Creating a sporting habit for life

Our Ref: SE/CL/2015/38562/N

**Application No:** 14/02121/OUT  
**Site Address:** Proposed Himley Village, North West Bicester, Middleton Stoney Road, Bicester, Oxfordshire  
**Proposal:** Development to provide up to 1,700 residential dwellings (Class C3), a retirement village (Class C2), flexible commercial floorspace (Classes A1, A2, A3, A4, A5, B1 and C1), social and community facilities (Class D1), land to accommodate one energy centre and land to accommodate one new primary school (up to 2FE) (Class D1). Such development to include provision of strategic landscape, provision of new vehicular, cycle and pedestrian access routes, infrastructure and other operations (including demolition of farm buildings on Middleton Stoney Road)

Drawing Title
Landscape - Parameter Plan 3

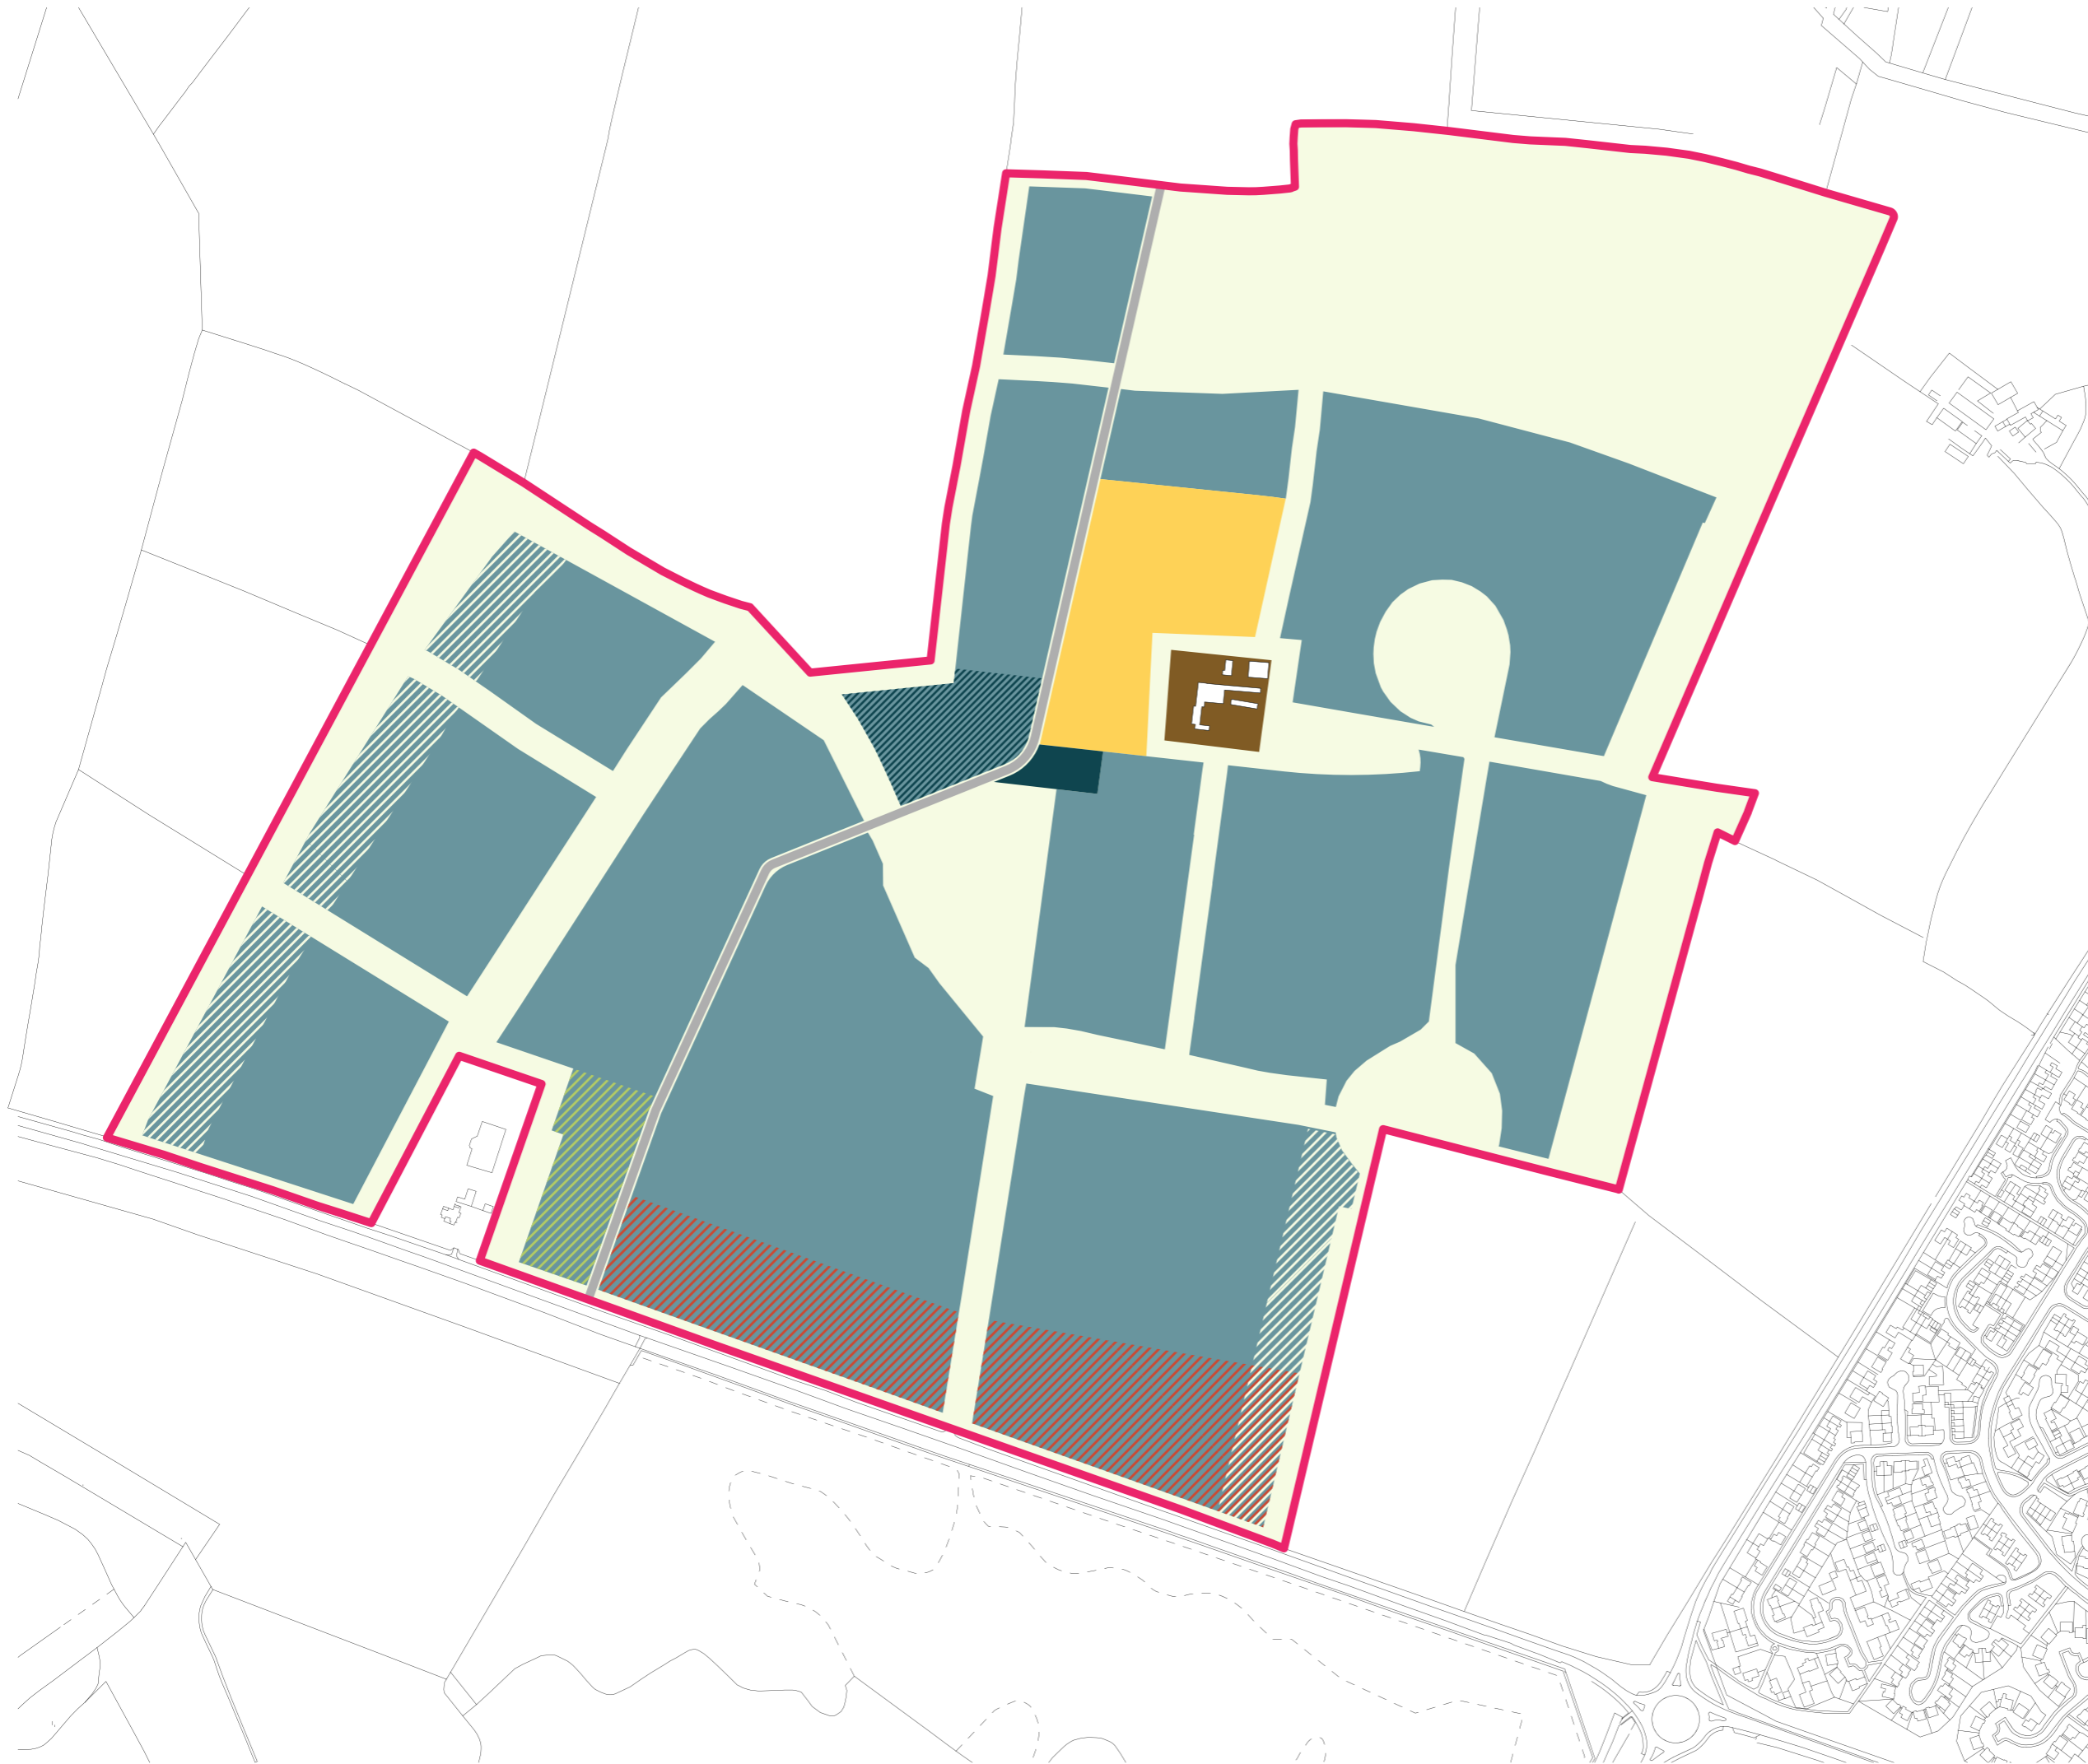
The application is accompanied by a Landscape Parameter Plan 3 (drawing numbered FHA621L01P), a Land Use Parameter Plan 4 (drawing numbered 592-PL-103 Rev A), and an Illustrative Masterplan (drawing numbered 592-SK-026). These drawings show a primary school with its own playing field near the centre of the site and a separate, larger area of land laid out as playing fields on the northern edge of the site. Generally, the plans accord with the Masterplan Framework (drawing numbered BIMP6 01 rev A) contained in the draft North West Bicester Supplementary Planning Document (p.62).

It is unclear what is meant by the term “informal pitches”. Playing pitches need to be properly constructed and formally laid out in order to be fit for purpose for sport.
